# Sydney Metropolitan Development Authority

28 June 2011

**RE: MAJOR PROJECT – EXHIBITION OF ENVIRONMENTAL ASSESSMENT FOR SYDNEY UNIVERSITY ABERCROMBIE PRECINCT REDEVELOPMENT (MP07\_0158)**

Drawing title
SUBDIVISION PLAN

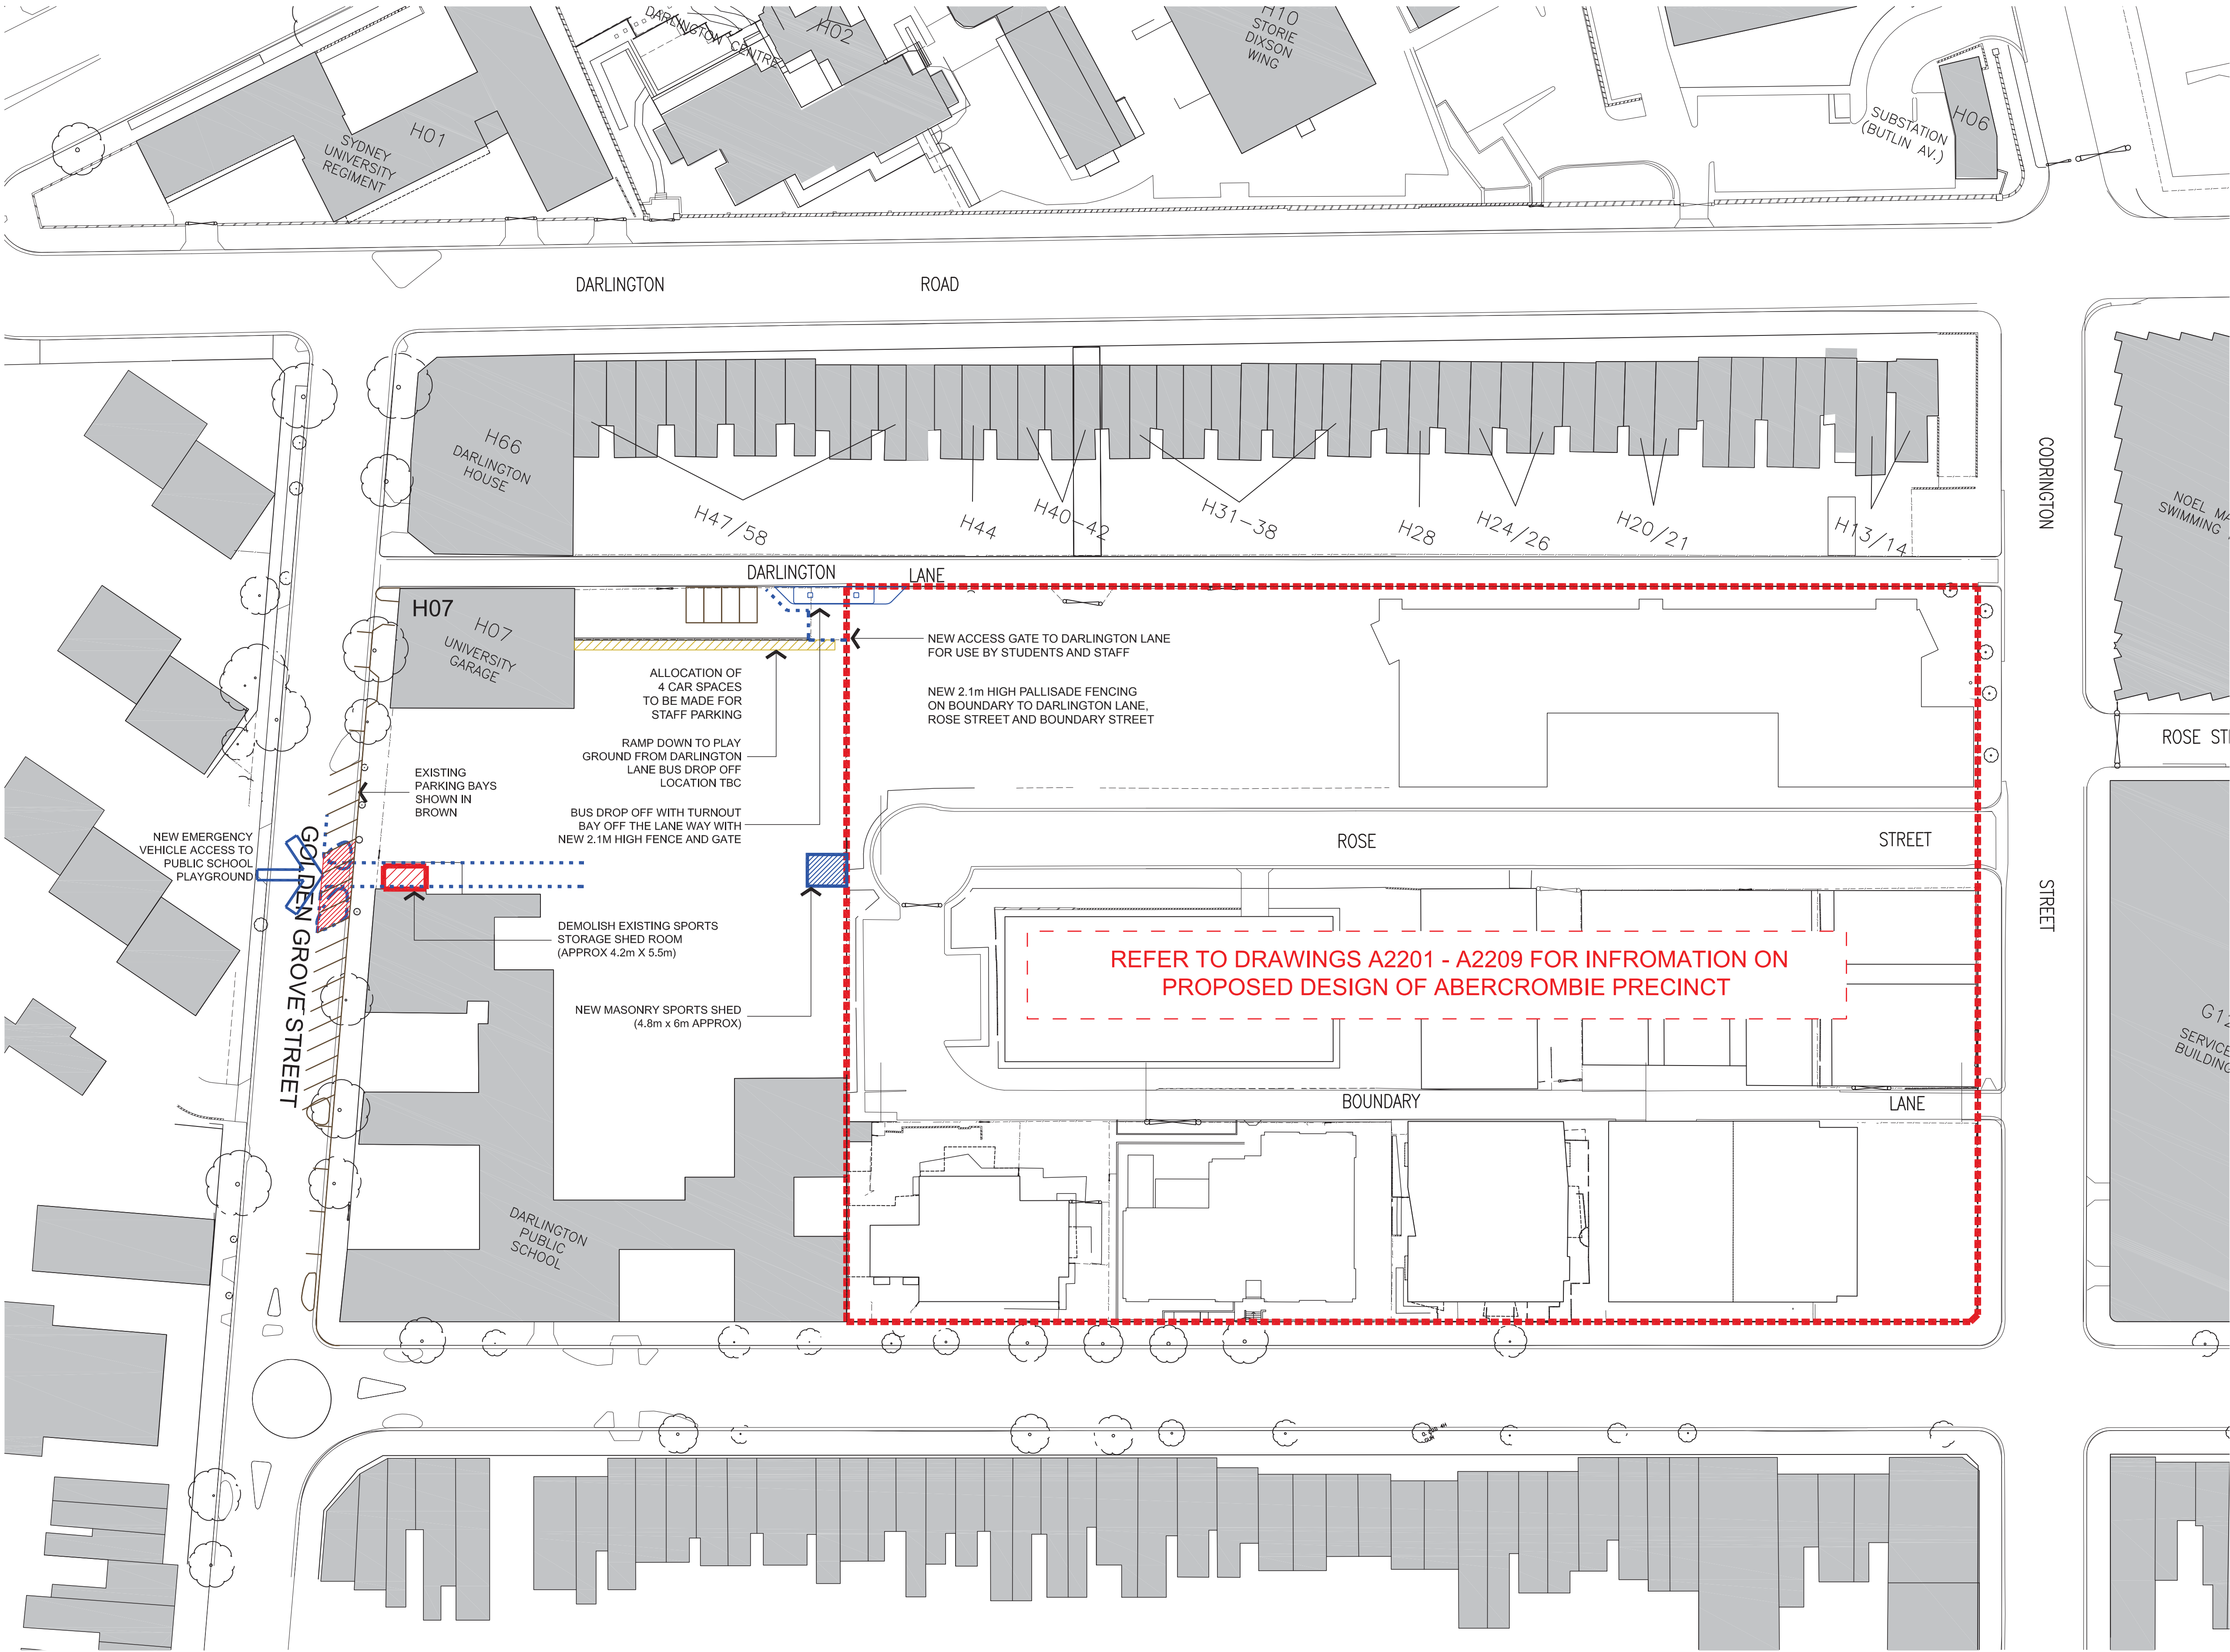
The subdivision will consolidate the existing lots, including the roads, and the creation of two new lots, one lot with are of approximately 17,017 sqm to accommodate the business school and a second lot of approximately 2333sqm to accommodate the student housing. No objection to this is raised, although it would be preferable if the student housing was not strata subdivided, so the use remains flexible and communal uses are readily available and properly managed.
